Application number: 2025/92242	
What is the application for?:	Reserved matters application (including consideration of appearance, scale and l
Address of the site or building:	Land off, Hermitage Park, Lepton, Huddersfield, HD8 0JU
Postcode:	WF2 7UA

User comments

Drawing Title
Tree Protection Plan 2 of 2

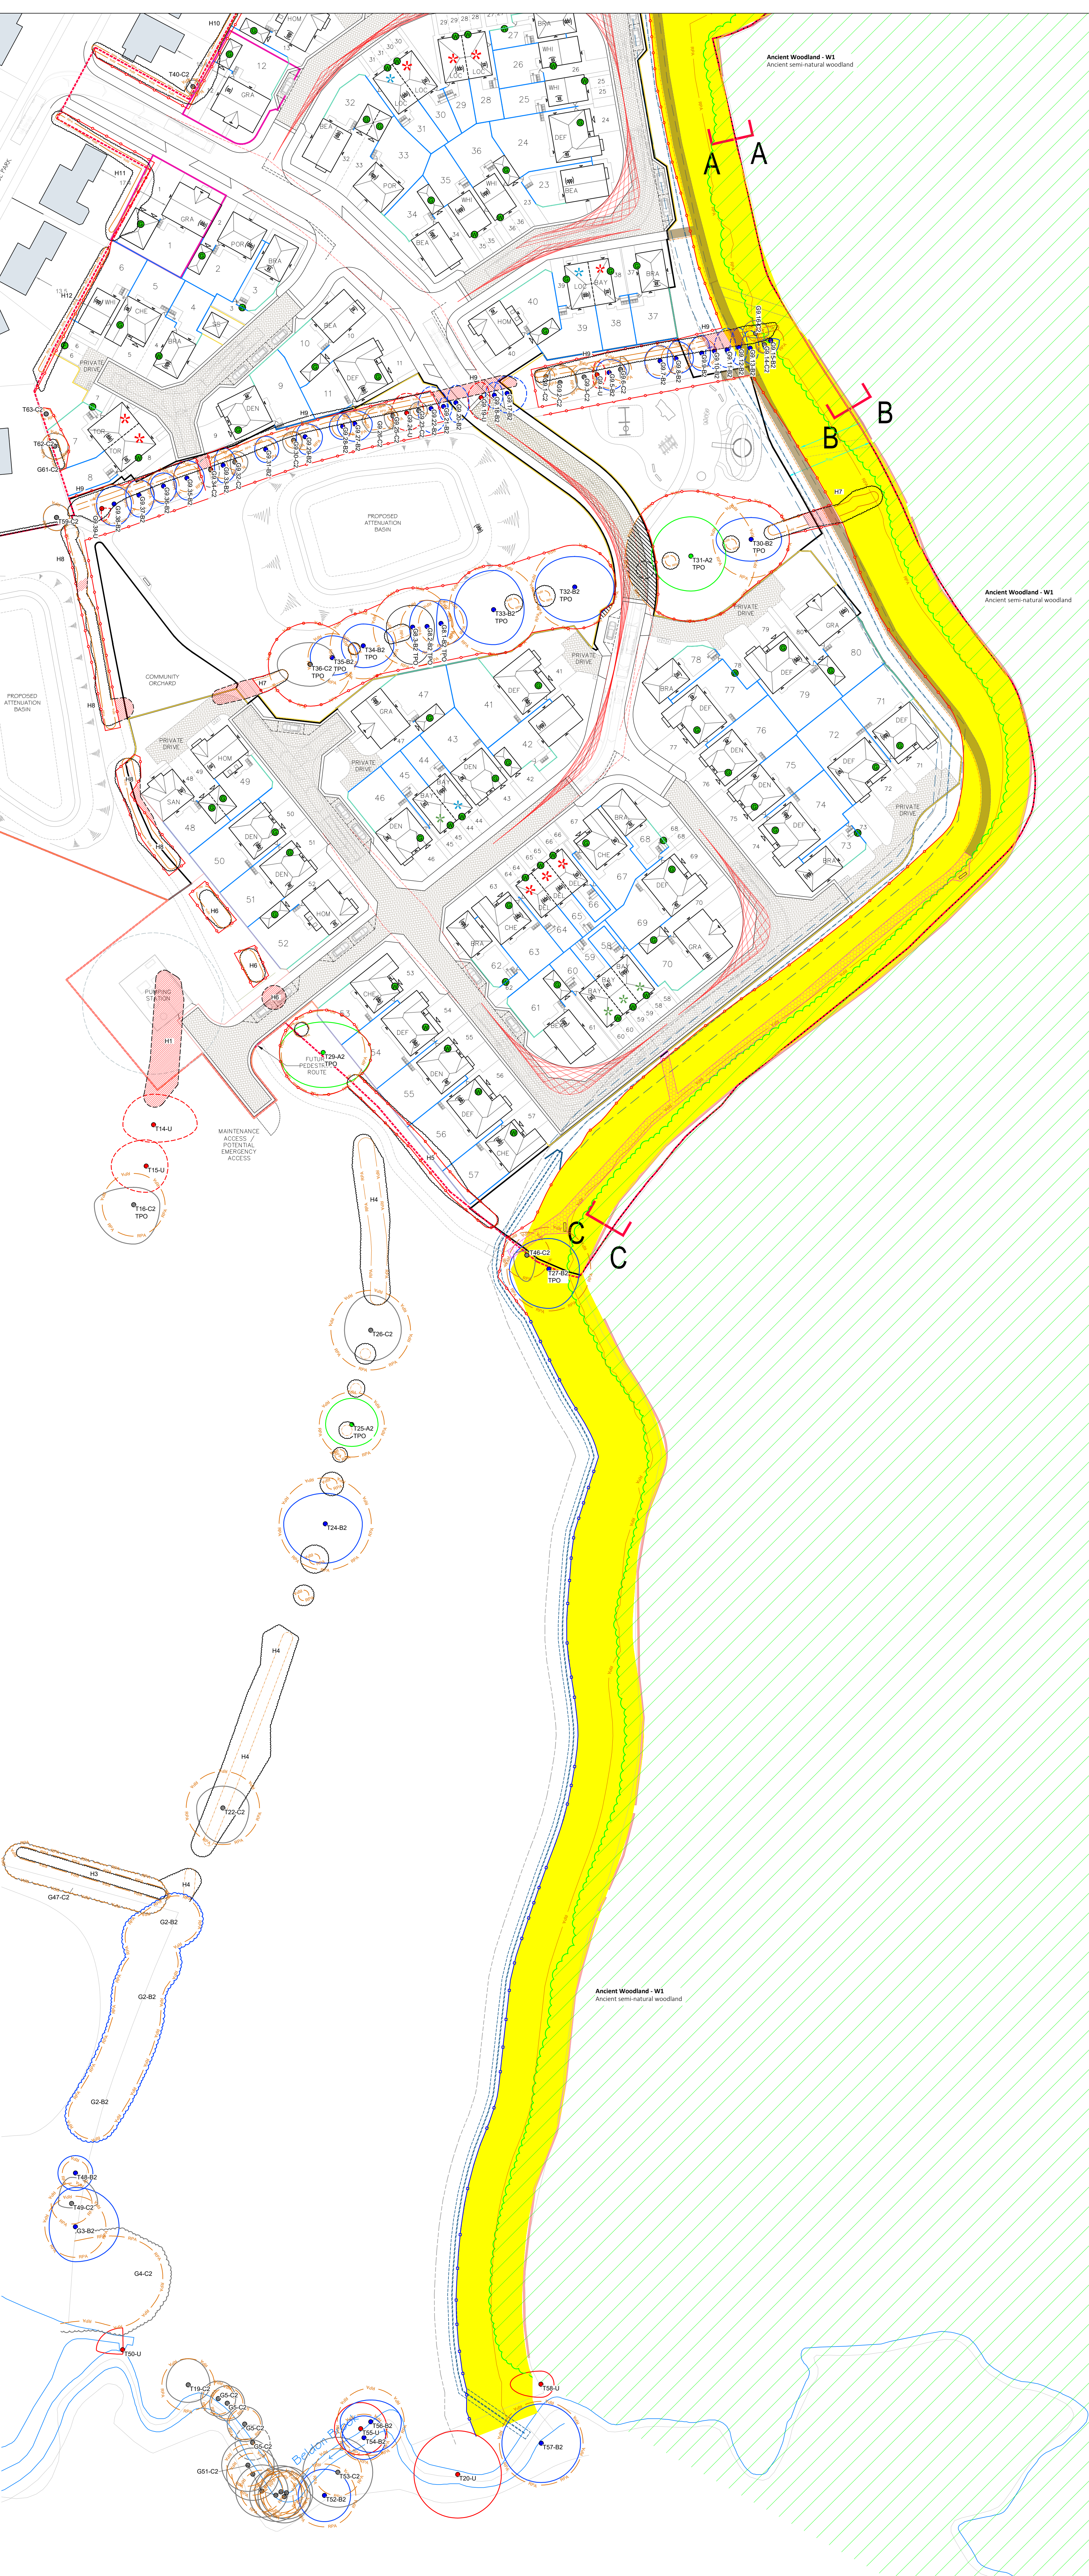
Type of comment: An objection	
Do you wish your comments to be published on the website anonymously?	No
My main objection is the buffer between this development and the ancient woodland. Its ridiculous to suggest that 15m is sufficient. Whist the 15m protects the roots, which should be standard for any preserved tree, it goes absolutely no where to actually PROTECTING the tree itself. A larger buffer would ensure that the biodiversity of the woodland was protected more. The Woodland Trust advocates for a 50-meter buffer as a precautionary measure to protect ancient woodland from potential damage. Yes we need to develop areas, and in my opinion Green Belts should never be considered, but we absolutely must protect trees and woodland!
